AENC-NG-CNS-REP-0208

Norwich to Tilbury

Document: 8.1 Errata List

Planning Inspectorate Reference: EN020027

Drawing Number:
 10059280-ARC-EHR-ZZ-DR-ZZ-00401

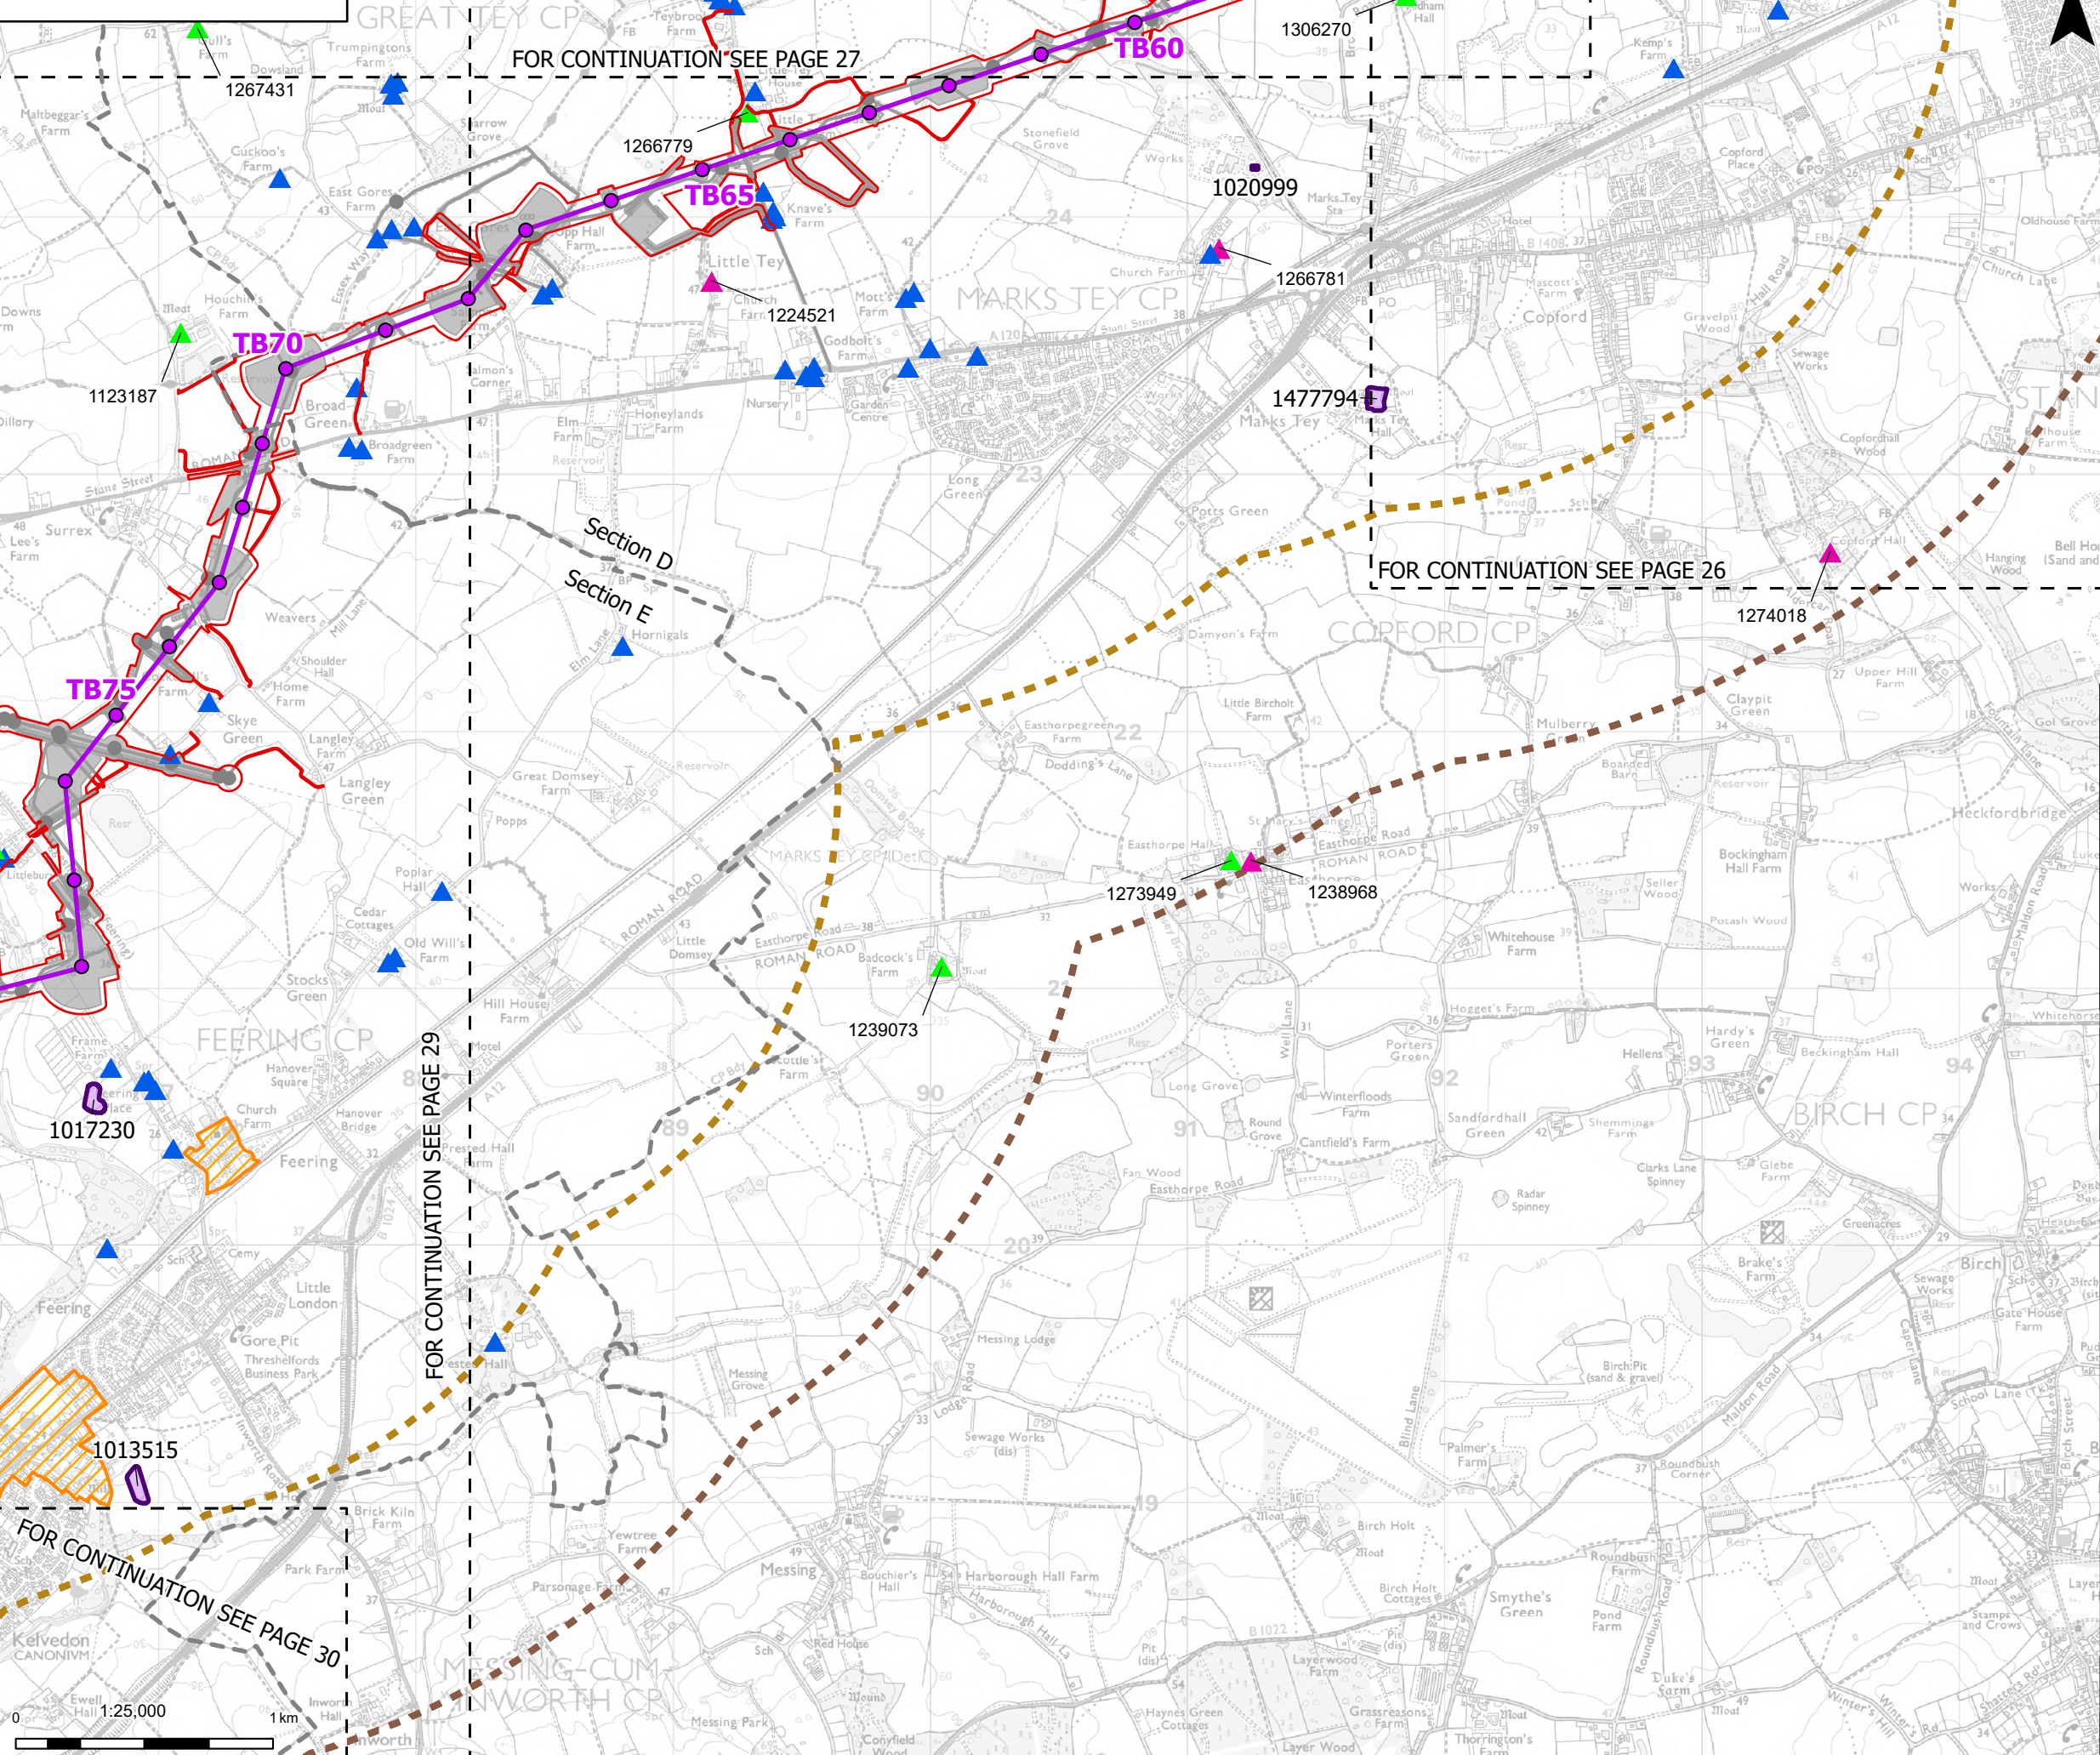
REP1-063	6.11.A1 Environmental Statement Appendix 11.1 - Historic Environment Baseline Report	Figure A11.1.1 - Designated Heritage Assets	Updated figure to remove conflict between labels and assets.	<p>Figure A11.1.1 - Designated Heritage Assets has been updated and is replaced by Figure A11.1.1 - Designated Heritage Assets (Rev D) submitted at Deadline 4.</p> <p><i>The updated figure does not alter the conclusions reported in 6.11 Environmental Statement Chapter 11 - Historic Environment [AS-068]. This update is included following a request from Examining Authority – particularly for Kings Farmhouse (1266530) and Bragg (1267411) in HE 1.5 [REP3-074] at Deadline 3.</i></p>
AS-068	6.11 Environmental Statement Chapter 11 – Historic Environment	Paragraph 11.7.16, Page 122	Correction of listed building grade and value.	<ul style="list-style-type: none"> The mediumhigh value Grade II* listed 'Creeting Hall' (1352073) <i>The correction of the listed building grade and value does not alter the conclusions reported in 6.11 Environmental Statement Chapter 11 - Historic Environment [AS-068] – the asset was assessed as a Grade II* listed building, however the * was omitted and an incorrect value was assigned in the submission document in error. This errata is included following a request from Examining Authority in HE 1.25 [REP3-074] at Deadline 3.</i>
